Our Ref: BR/87/15/PDH
Your Ref:

Application for Prior Notification for a householder extension

Development Notification under extended permitted development rights for to replace existing conservatory with a extension extending 4 metres from the original wall of the dwelling house, 3.6 metres high with an eaves height of 2.1 metres

Location 68 Hatherleigh Gardens Bognor Regis

PLAN ELEVATION

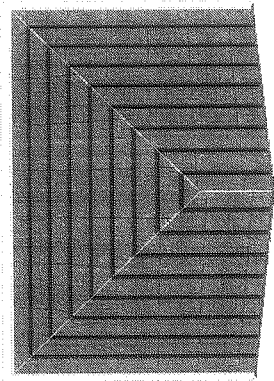
The extension shown on the block plan only measures 3.5m. Please amend to show it extending 4m.
